RE: **Jomar/Martinez Residence**
2123 Candelaria NW
Grading Plan Stamp Date: 8/23/18
Hydrology File: G13D035

Based on the submittal received 8/23/18, the Grading Plan is approved for Plat and Grading Permit. On the Plat, provide a drainage easement over the ponds and annotate using the [Plat Drainage Easement Note](#). This note replaces the need for a separate drainage covenant.

ENGINEER'S SEAL 8/23/18 8/1/18 DAVID SOULE P.E. #14522	2123 CANDELARIA RD JOMAR CANDELARIA RESIDENCE	DRAWN BY DEM
	GRADING AND DRAINAGE PLAN	DATE 7-31-18
 1608 CENTRAL AVENUE SE SUITE 201 ALBUQUERQUE, NM 87106 (505) 972-0899		JAMAR CANDELARIA G&D
		SHEET # C1
		JOB #

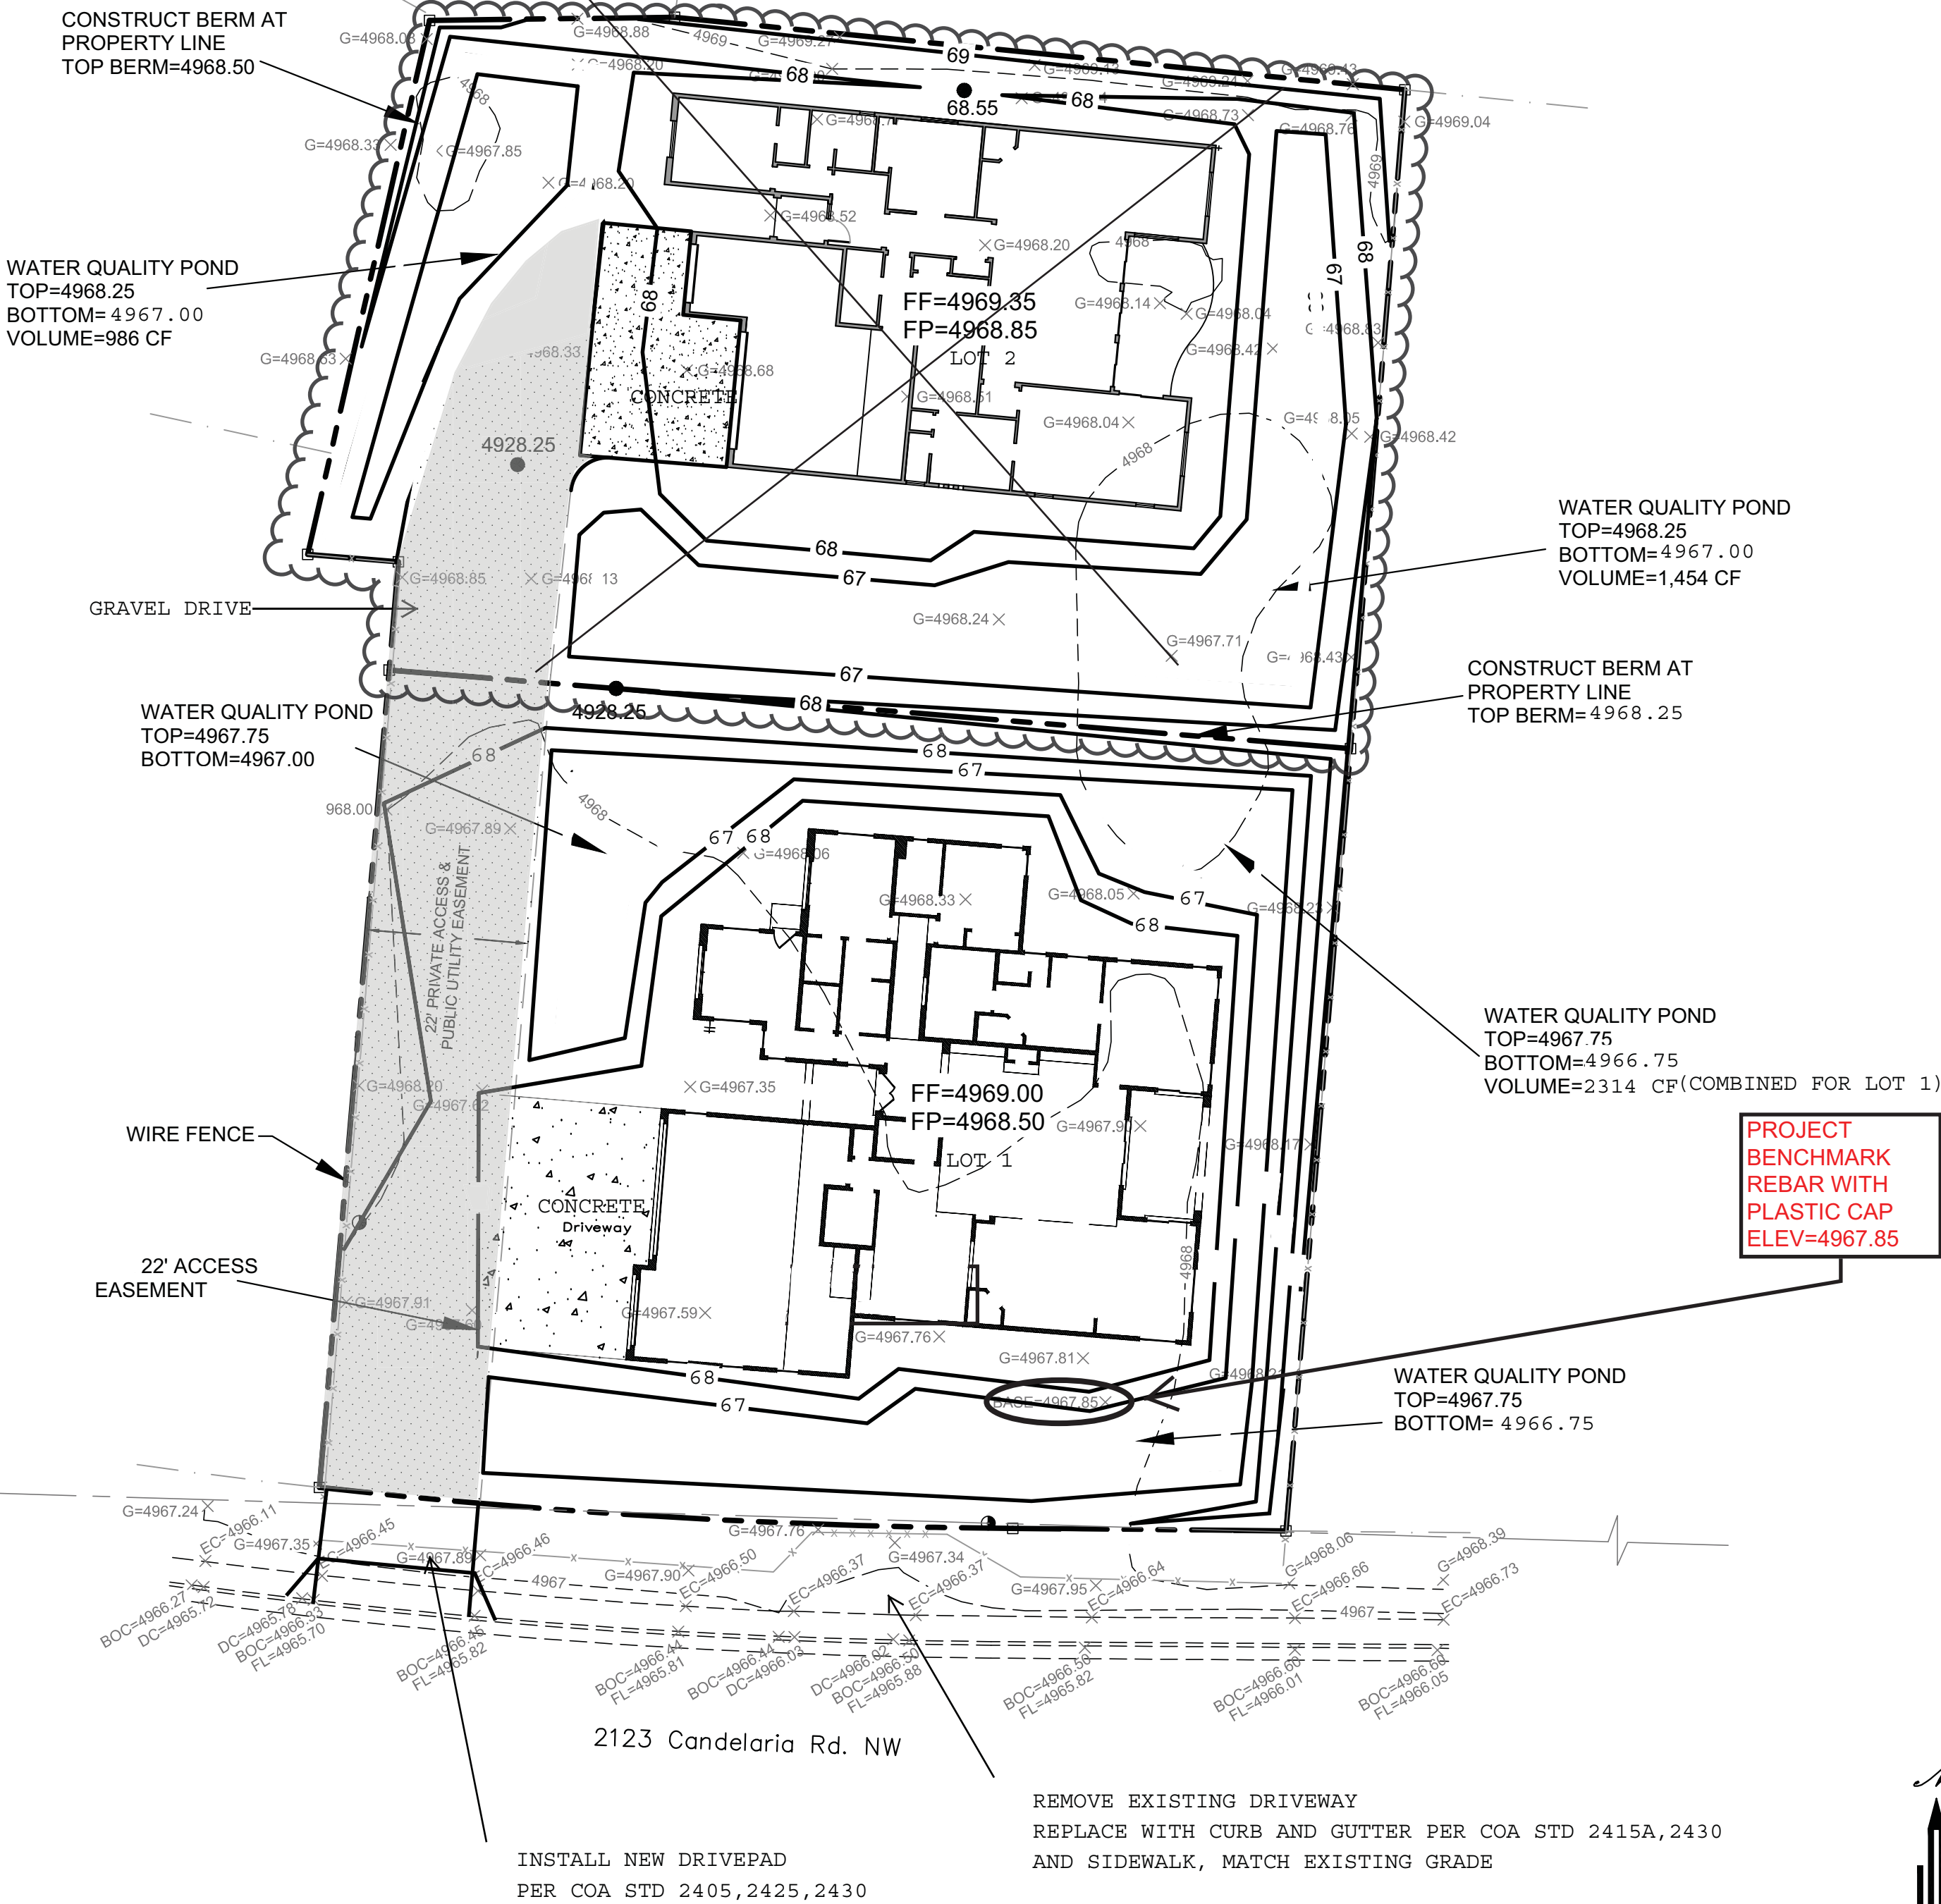
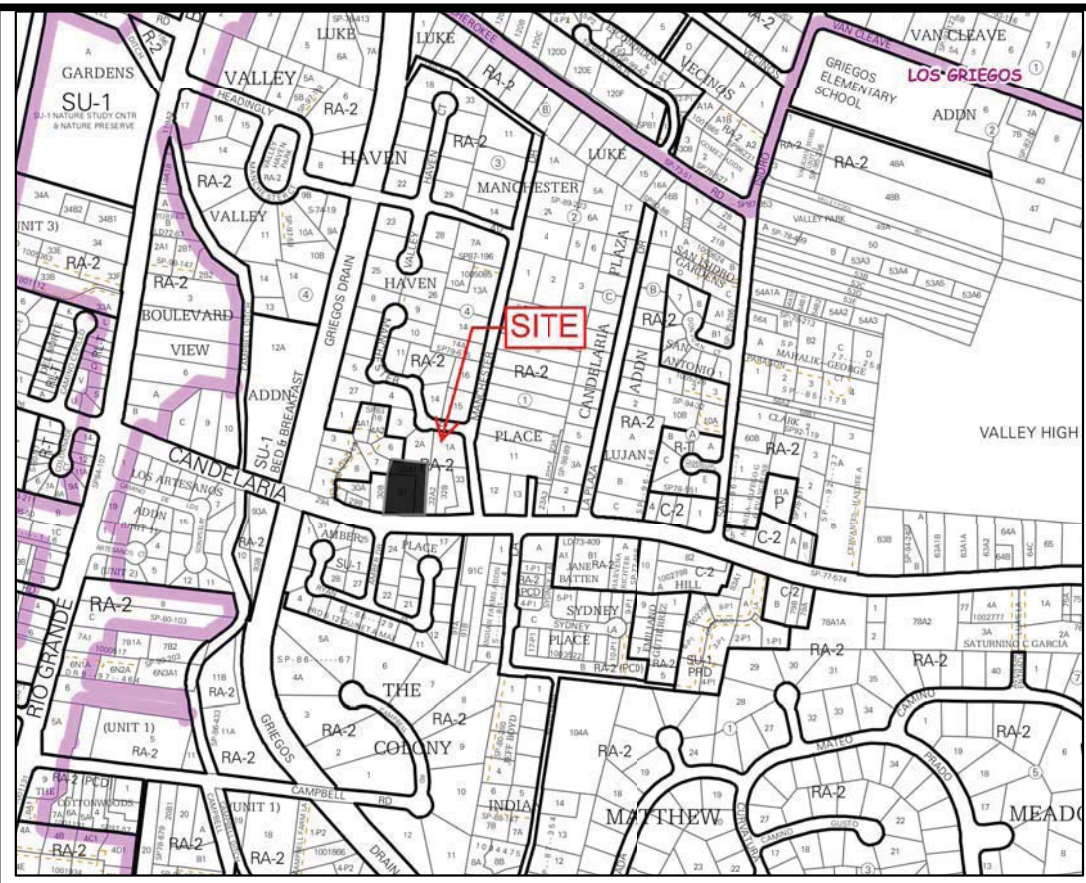
2. Provide topographic survey for the adjoining properties (~10' across the property line); ensure your proposed grades tie in at the property line. **SURVEYOR COULD NOT ACCESS ADJOINING LOTS, WE HAVE PROVIDED GIS LIDAR TO SHOW AREA IS FLAT**

3. Add note on the plan that "No work shall be performed in the public ROW without an approved Work Order or Excavation Permit."

ADDED NOTE #4

ENGINEER'S SEAL	2123 CANDELARIA RD JOMAR CANDELARIA RESIDENCE	DRAWN BY DEM
	GRADING AND DRAINAGE PLAN	DATE 7-31-18
8/1/18	 1608 CENTRAL AVENUE SE SUITE 201 ALBUQUERQUE, NM 87106 (505) 972-0899	JAMAR CANDELARIA G&D
DAVID SOULE P.E. #14522		SHEET # C1
		JOB #

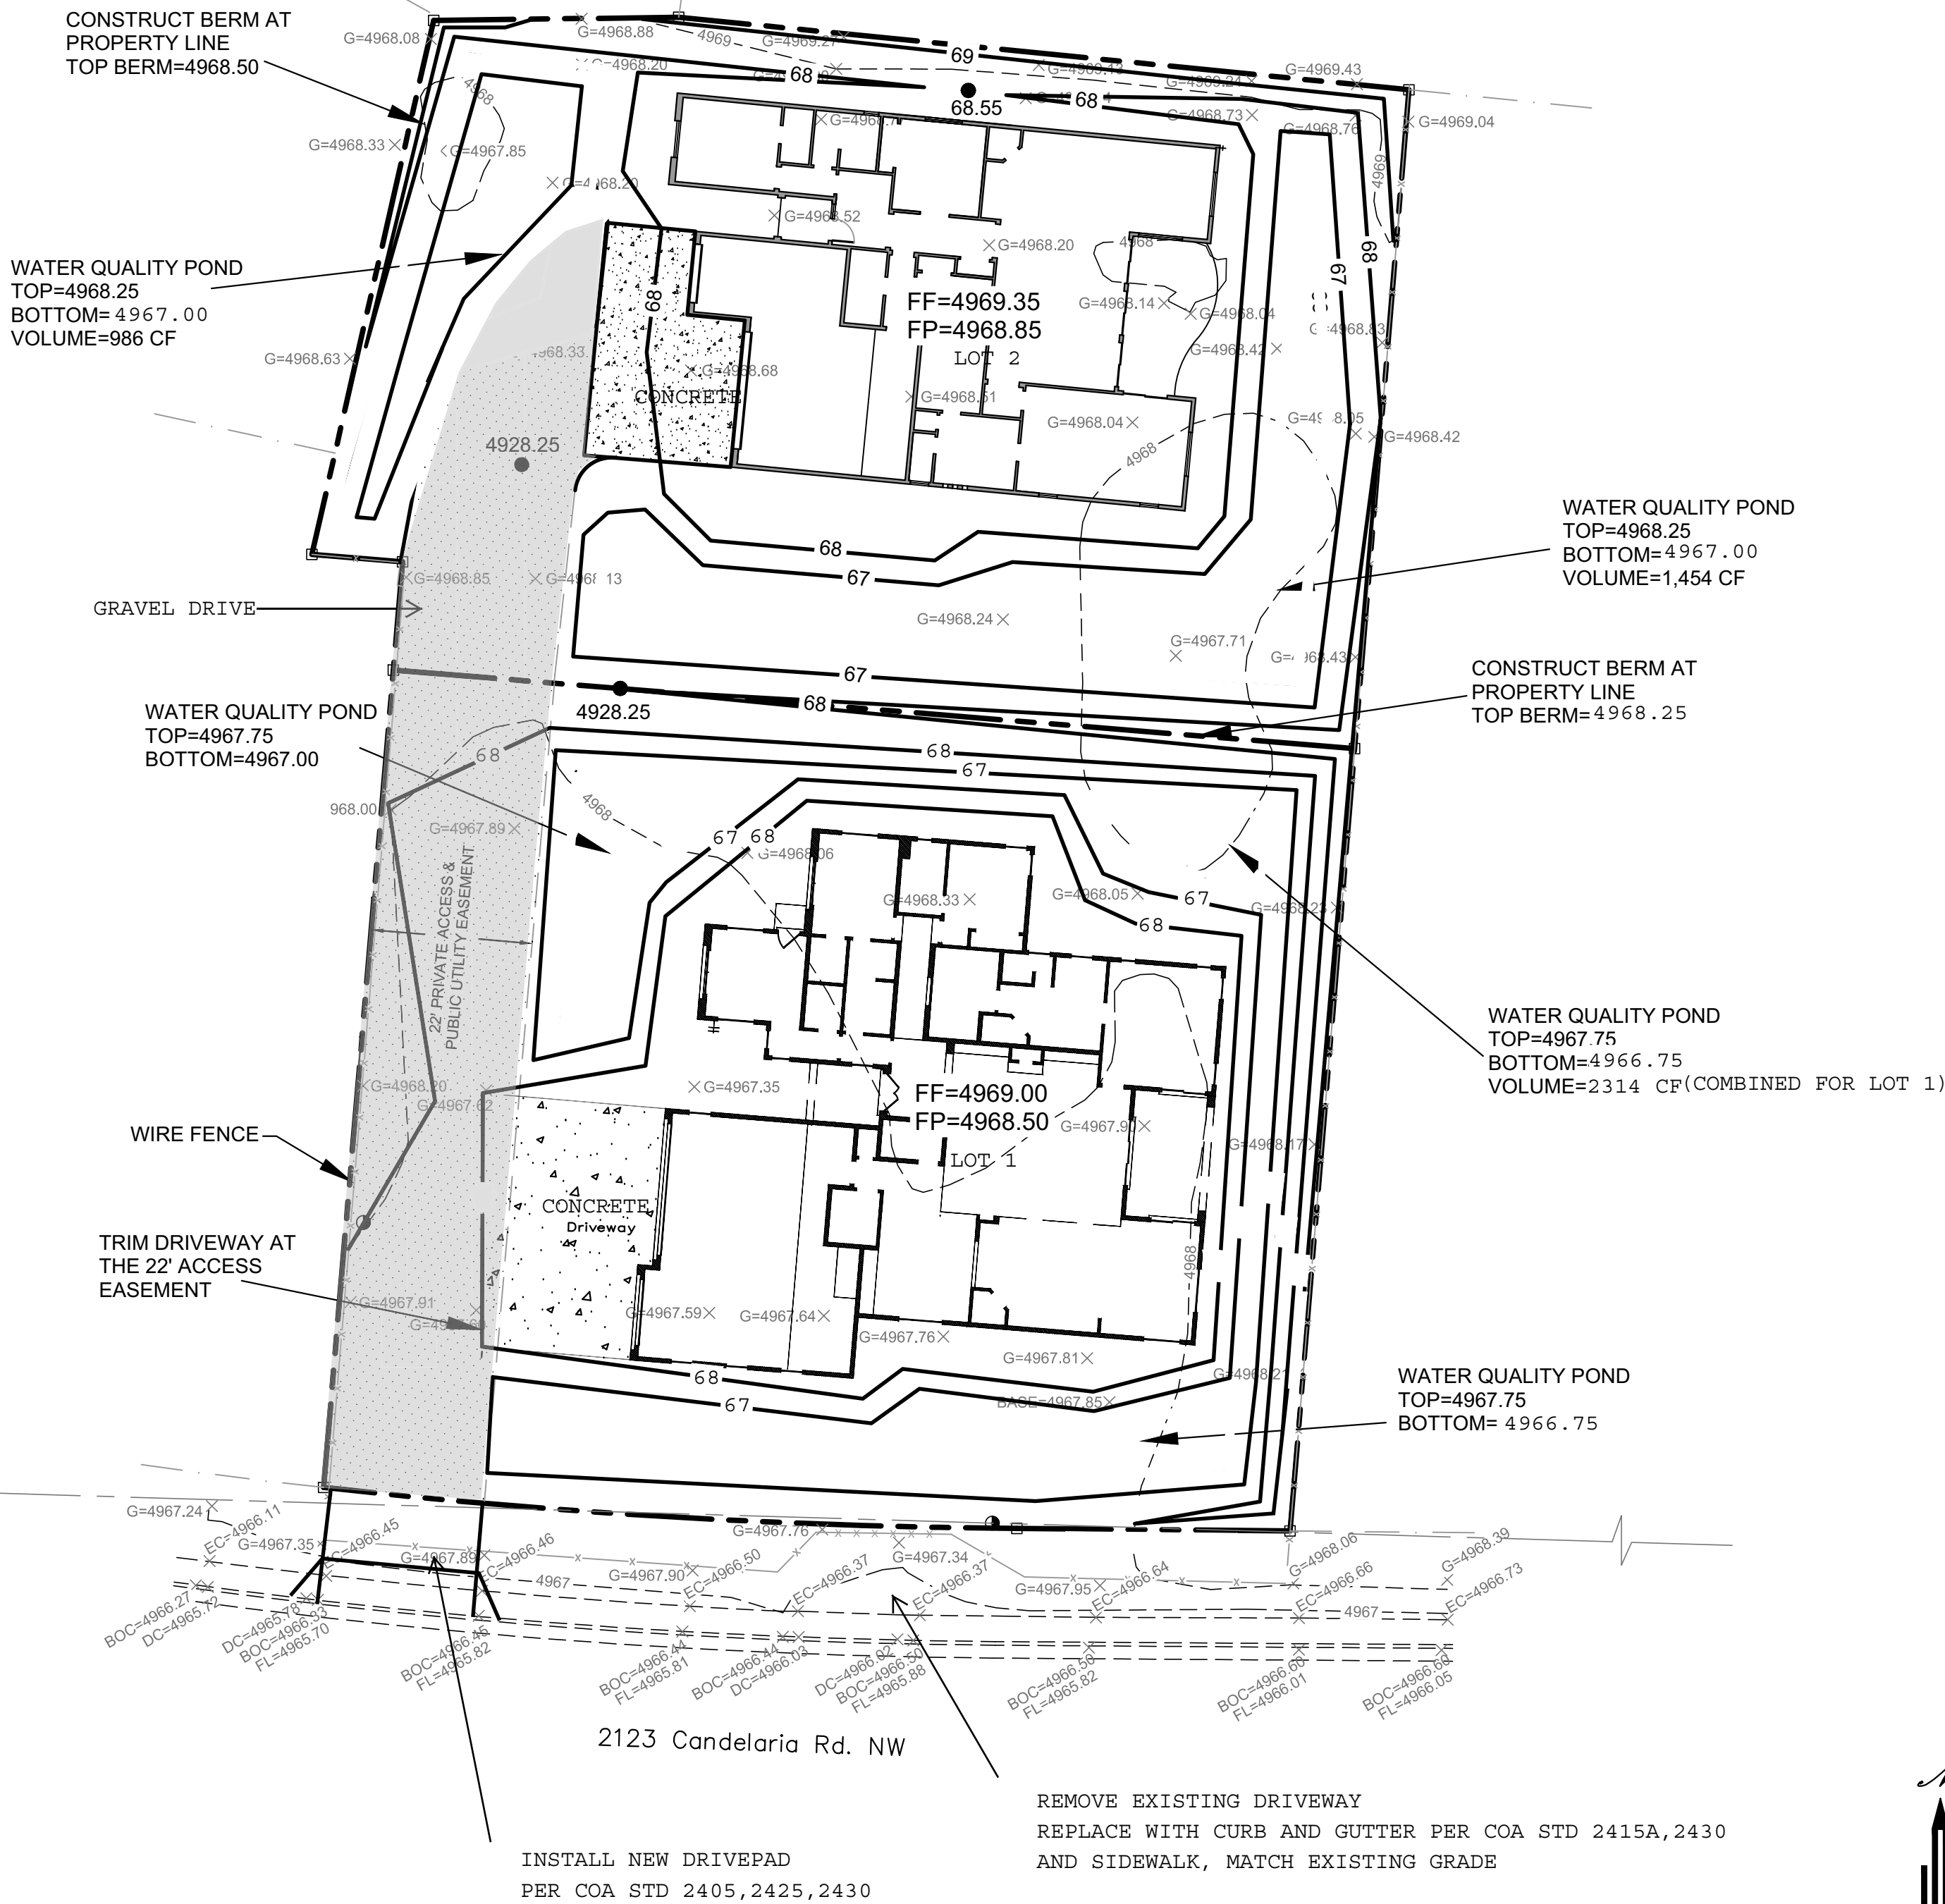
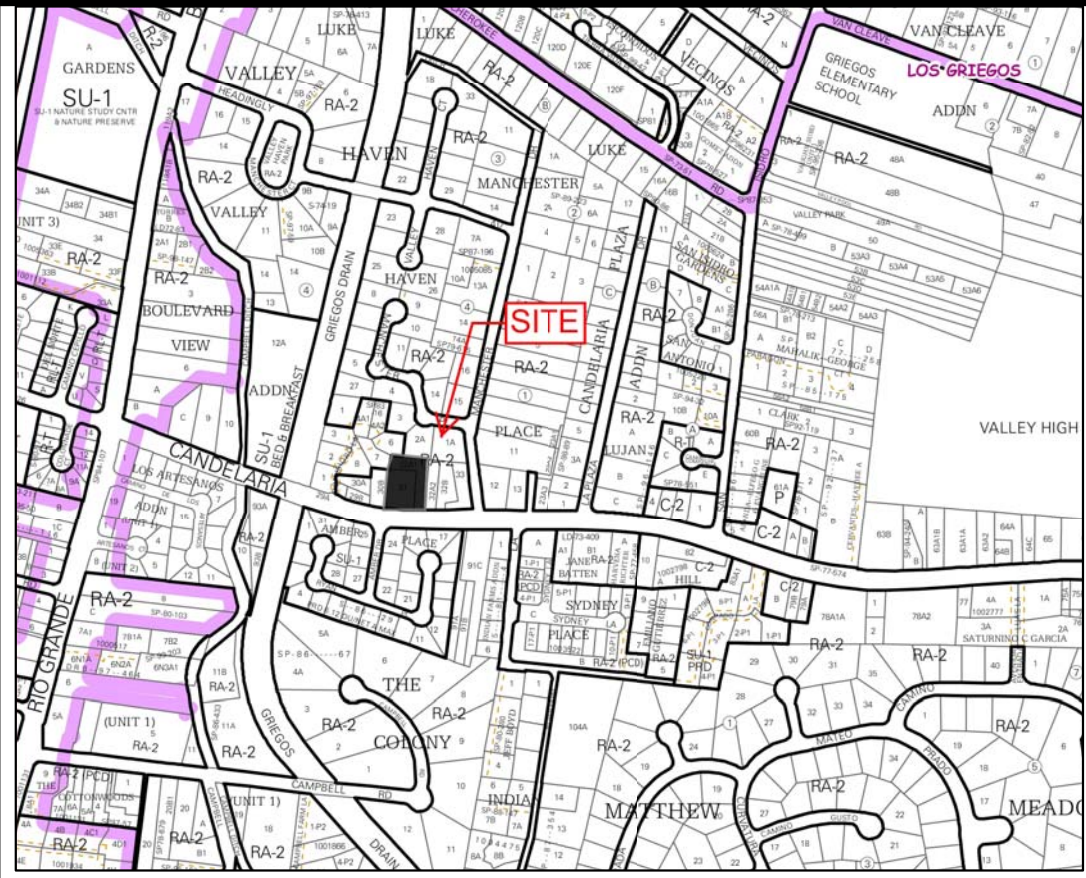
1. Include project benchmark. **ADDED**
